Monument Junction West Filing No. 1
Construction Documents Review (Streets, Storm Sewer and Final Drainage Report
Review) - Submittal 2

Date:	07/25/2022	Jacobs Engineering Group Inc.
Project no:	A.PN.CI.067	6312 S. Fiddlers Green Circle
Attention:	Debbie Flynn, Planner II	Suite 300N
Company:	Town of Monument:	Greenwood Village, CO 80111
Prepared by:	Mark Kitzmiller	United States
		T +1.720.286.2000
		www.jacobs.com

1. "Monument Junction West Filing No. 1 Construction Plan Set," by Classic Consulting, dated June 20, 2022.
2. "Final Drainage Report for Monument Junction West Filing No. 1," by Classic Consulting, dated July 2022.
3. CCES Responses to Submittal 1 review memo. **Note: Per e-mail attached, Jacobs did not have any comments on storm or pond plans.**

MONUMENT JUNCTION WEST FILING NO. 1
PUBLIC STREET IMPROVEMENT PLANS
STREET IMPROVEMENT PLAN & PROFILES

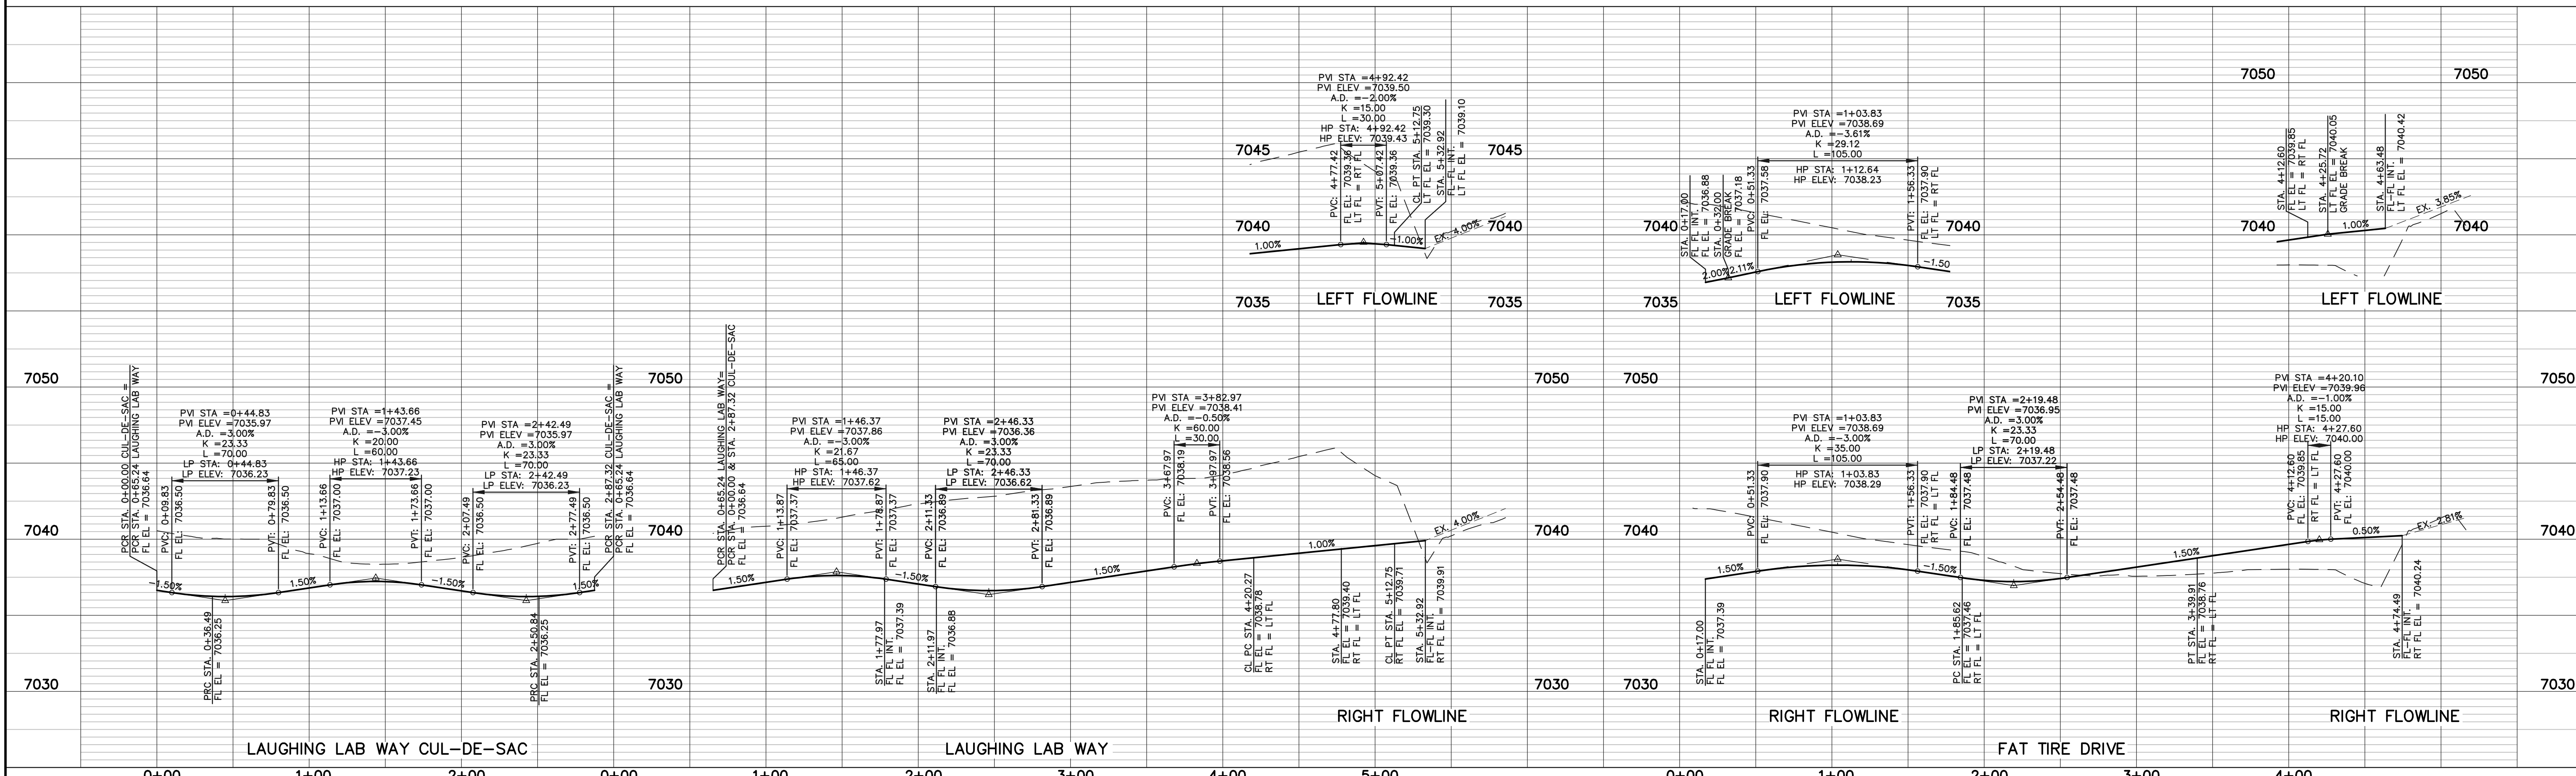
1. Curb return radii C4 and C5 do not meet the minimum curb return radius requirements. ***Not addressed. Curb return radii requirements are listed in Table 5.2 of Appendix A of the Town of Monument Roadway Design and Technical Criteria. A waiver would be necessary to reduce curb returns radii from 30 feet to 20 feet.*** **Waiver for curb returns now provided**

3. On Laughing Lab vertical right flowline profile, grade breaks are discouraged at station 3+82.97. Could there be a vertical curve? **Addressed**
4. Grade break at station 5+32.92 for Laughing Lab right flowline profile exceeds maximum grade break allowable for a curb return. **Partially addressed. Slope shown is for FL intersection. Clarify if that is perpendicular or parallel to intersecting road. If perpendicular, is the road slope really 4% there?** The exist. 4% slope shown is perpendicular and is the exist. superelevation grade of JCP that we must tie into.

5. K value for vertical curve at station 4+56.36 on Fat Tire Drive right flowline doesn't meet minimum requirements. **Not addressed. Intersection is currently stop condition but could have a signal in the future; therefore, K value needs to meet design speed of the road.** Design adjusted to meet K value criteria for future signalized intersection

6. Grade break on both the left flowline and right flow line profiles for Fat Tire exceeds maximum grade break at curb return. (LT station 4+63.48 and RT station 4+56.36). **Partially addressed. Slope shown is for FL intersection. Clarify if that is perpendicular or parallel to intersecting road. If perpendicular, is the road slope really 2.81% and 3.85% there?**

The exist. 2.81% and 3.85% slopes shown are perpendicular and are the exist. superelevation grade of JCP that we must tie into.

MONUMENT JUNCTION WEST FILING NO. 1
PUBLIC STREET IMPROVEMENT PLANS
STREET IMPROVEMENT PLAN & PROFILES

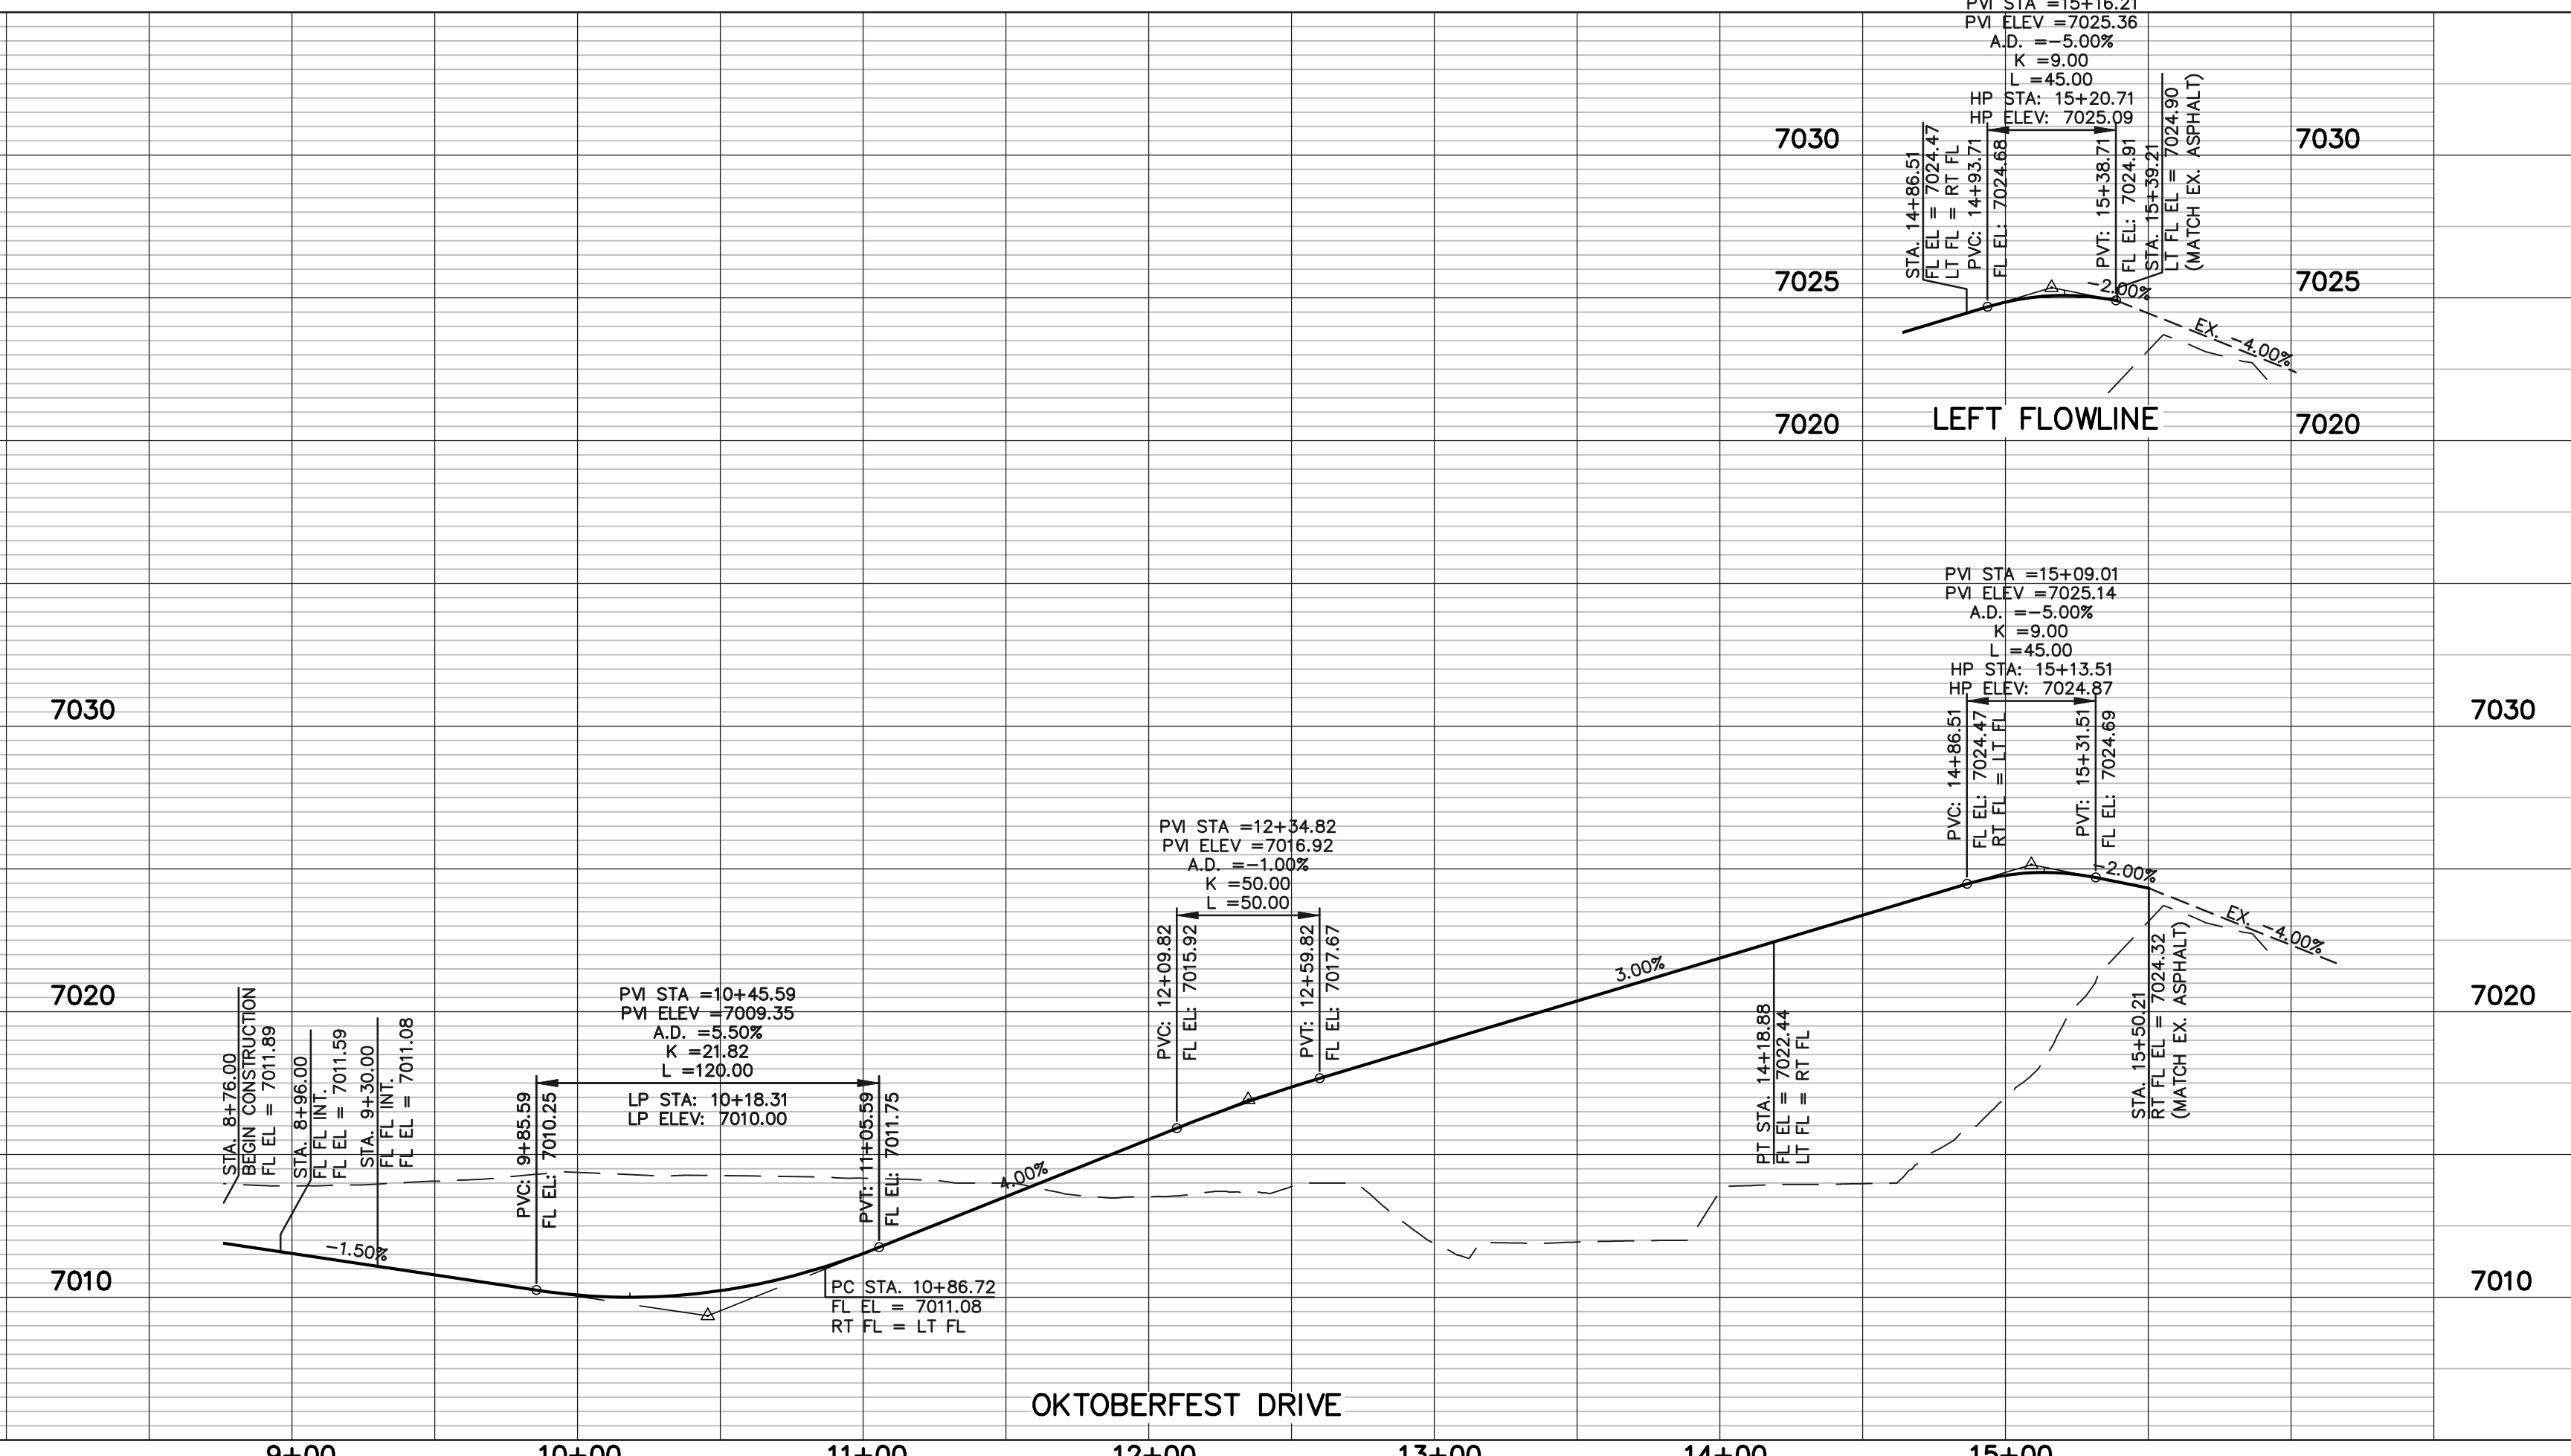
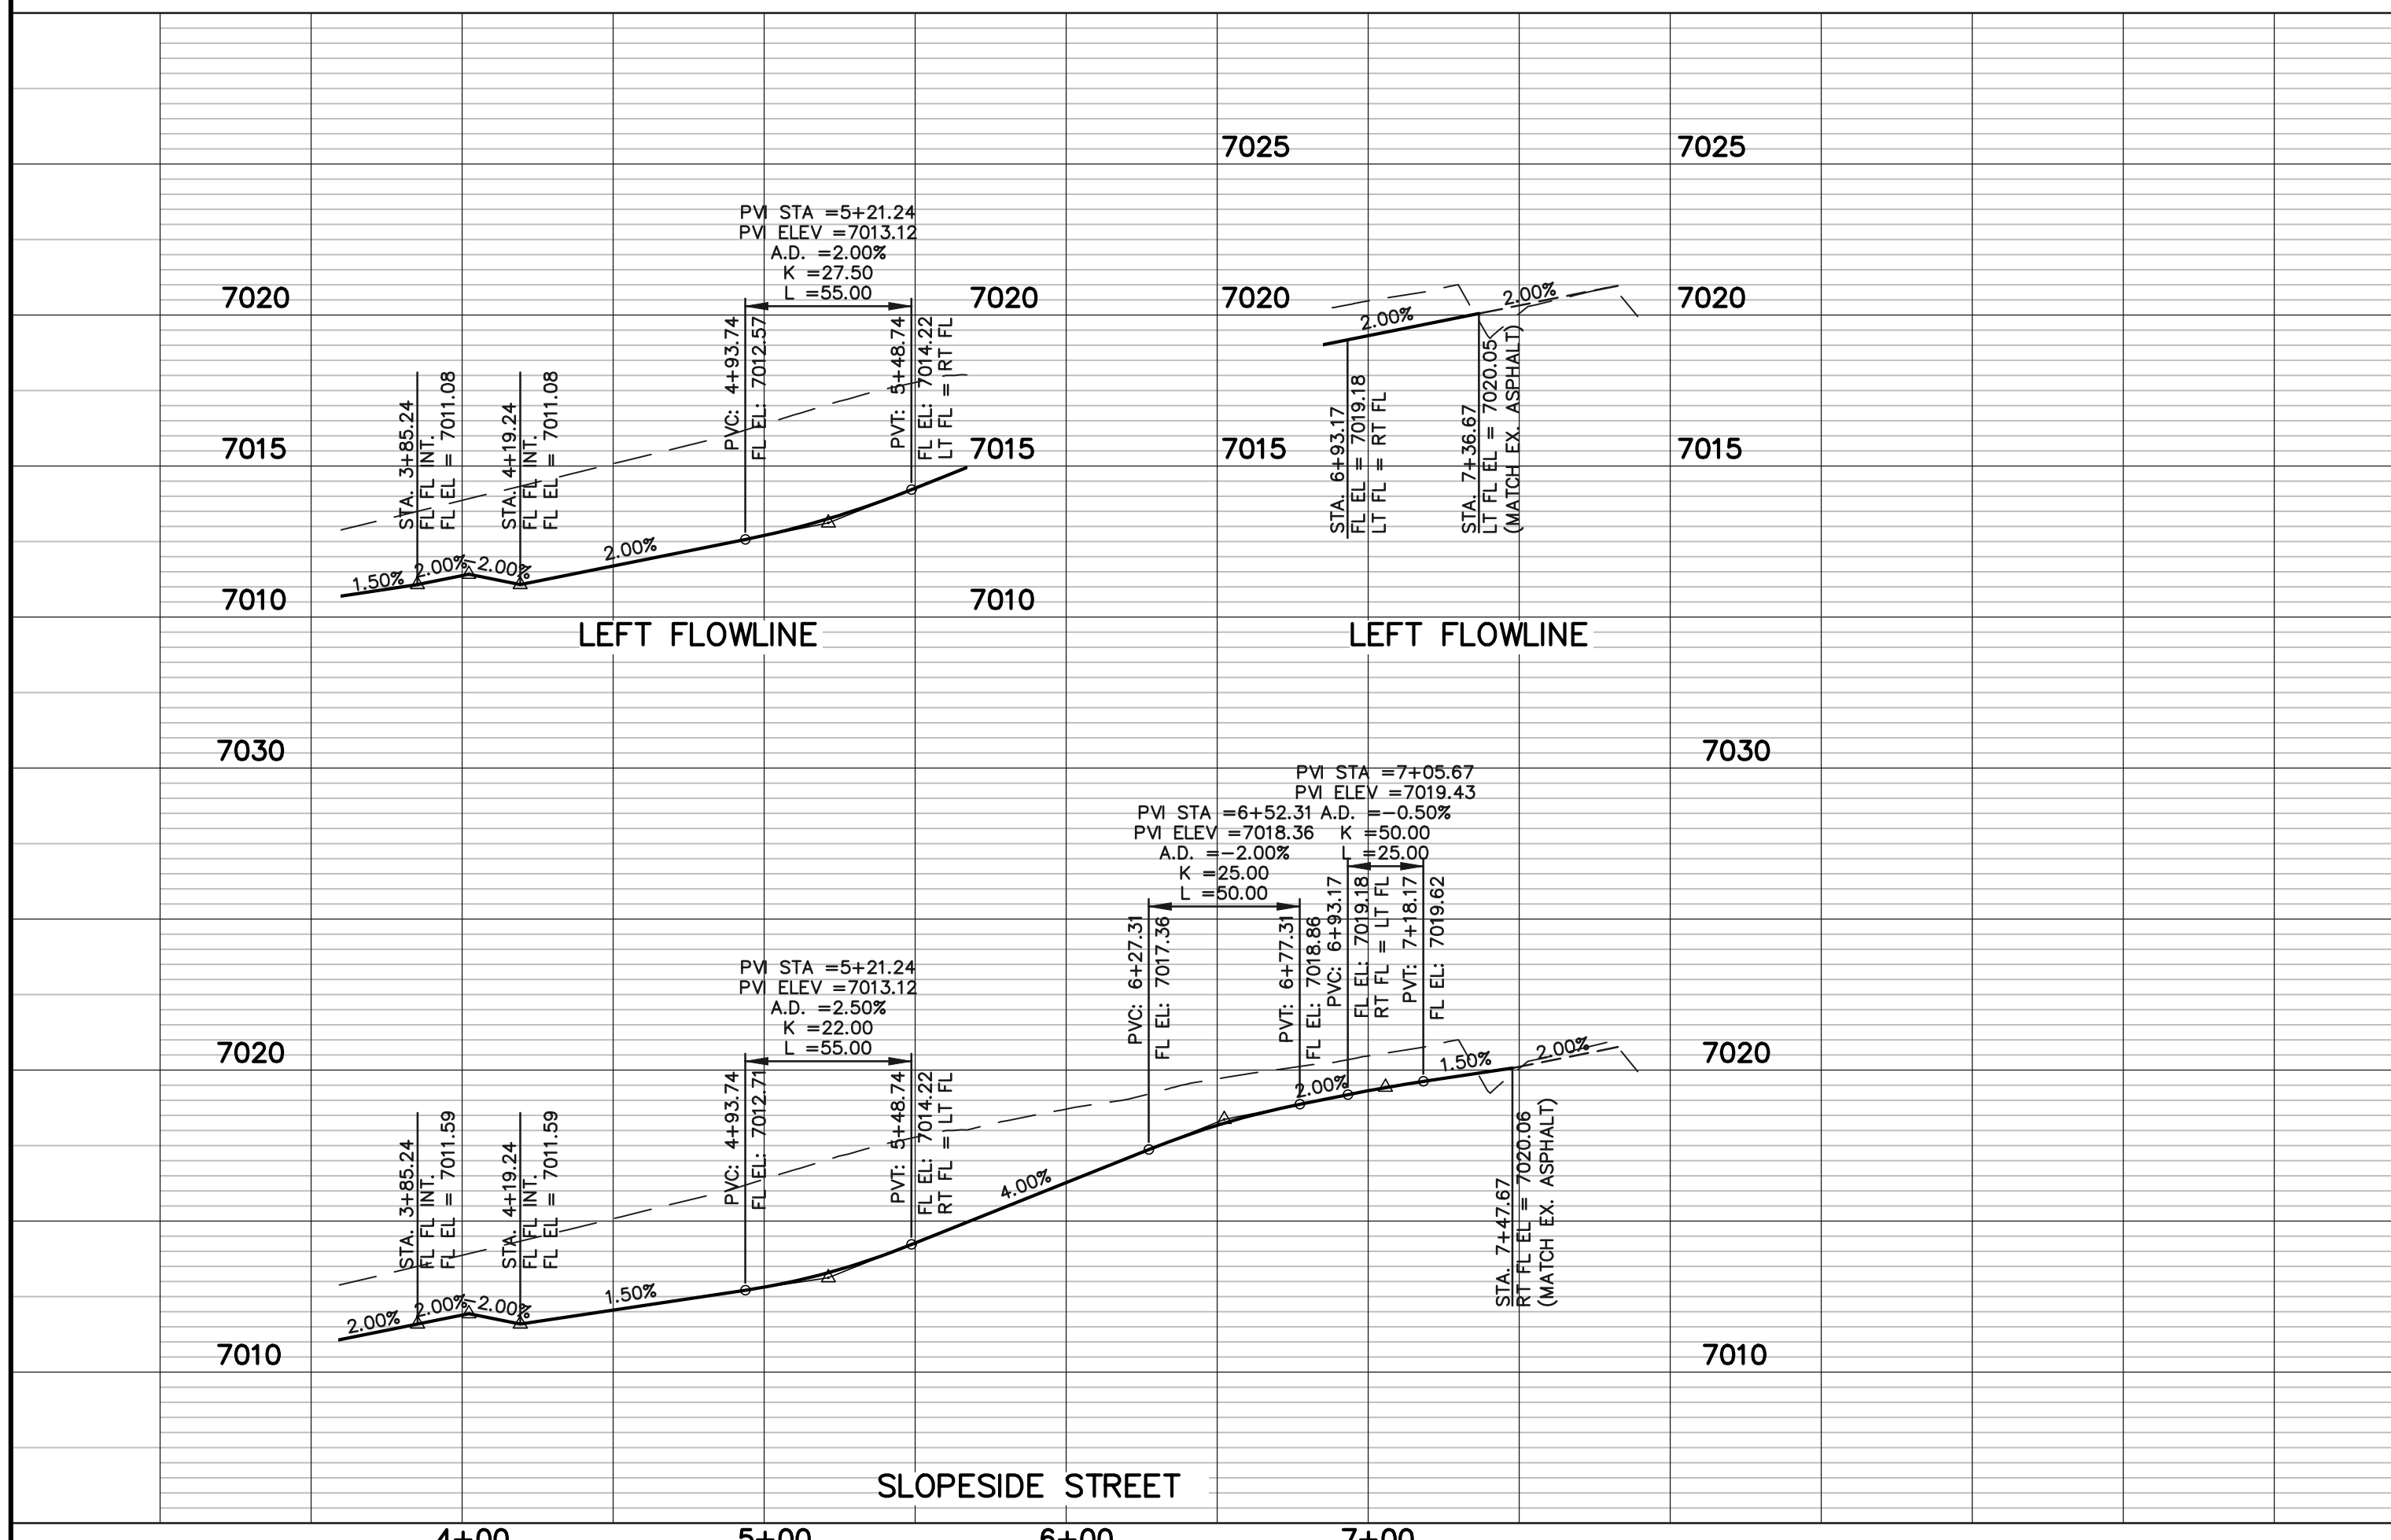
1. Curb return radii C12 and C13 do not meet the minimum curb return radius requirements. **Not addressed. Curb return radii requirements are listed in Table 5.2 of Appendix A of the Town of Monument Roadway Design and Technical Criteria. A waiver would be necessary to reduce curb returns radii from 30 feet to 20 feet.** Waiver for curb returns now provided

2. K value for vertical curve at station 15+09.01 for Oktoberfest Drive right flowline does not meet the minimum requirements. **Not addressed. Intersection is currently stop condition but could have a signal in the future; therefore, K value needs to meet design speed of the road.** This design follows the CDOT approach road std. M-203-1 and provides for a 20 mph design speed at the int. This int. is planned to be a RI/RO only and NO signal planned.

3. K value for vertical curve at station 15+16.21 for Oktoberfest Drive left flowline does not meet the minimum requirements. **Not addressed. Intersection is currently stop condition but could have a signal in the future; therefore, K value needs to meet design speed of the road.**

This design follows the CDOT approach road std. M-203-1 and provides for a 20 mph design speed at the int. This int. is planned to be a RI/RO only and NO signal planned.
